Application no: H16/1283/99

Description: Fascia Sign plus Projecting
Sign

Location: 12 Sheepmarket
Spalding
Lincs

Amendment: Stone fascia size changed, new position of projecting sign
Drawing No 101.

AMENDED PLAN
Ref.

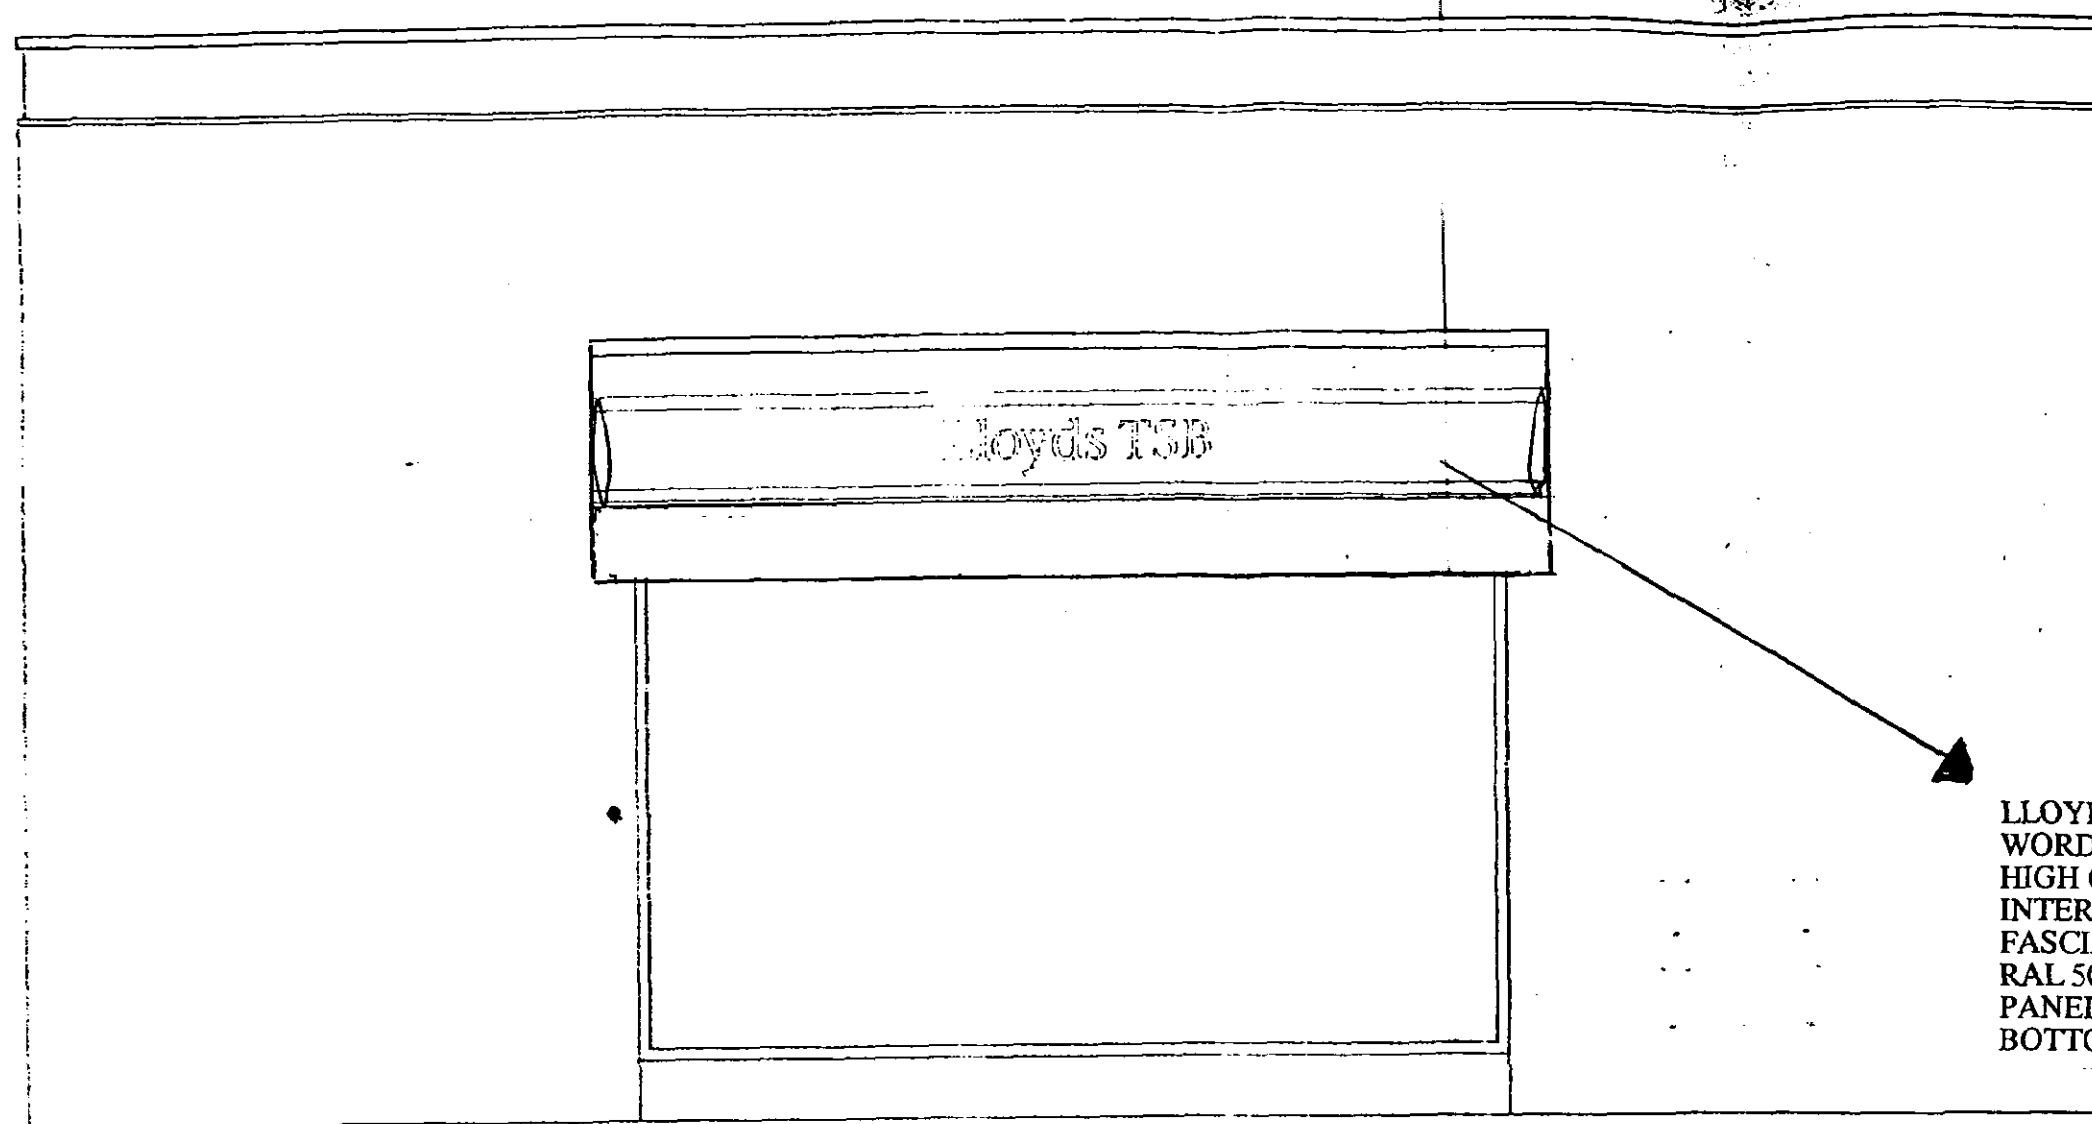
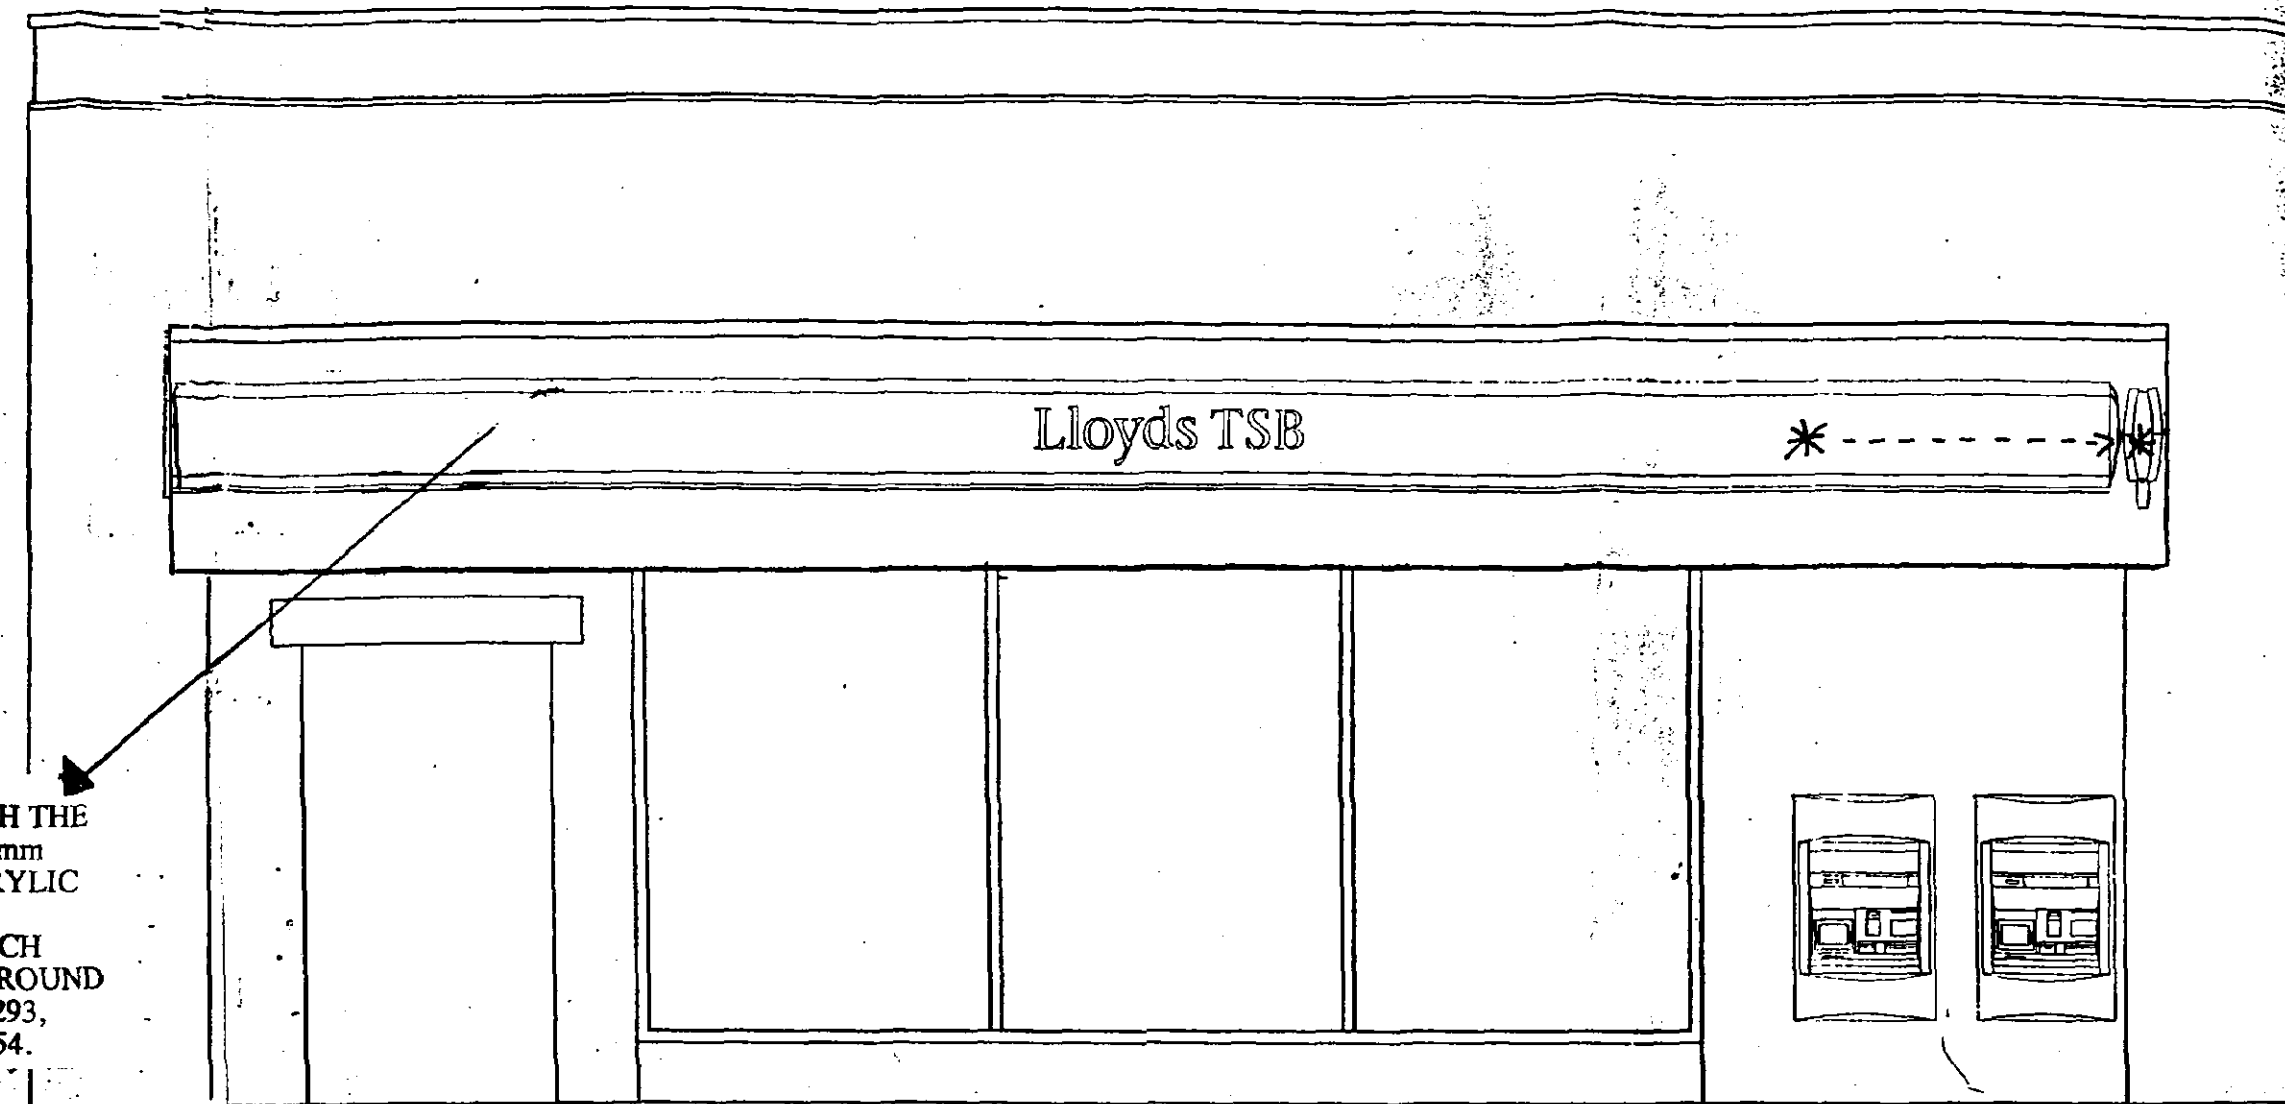
STONE FASCIA SIZE
CHANGED.

NEW POSITION OF
PROJECTION SIGN.
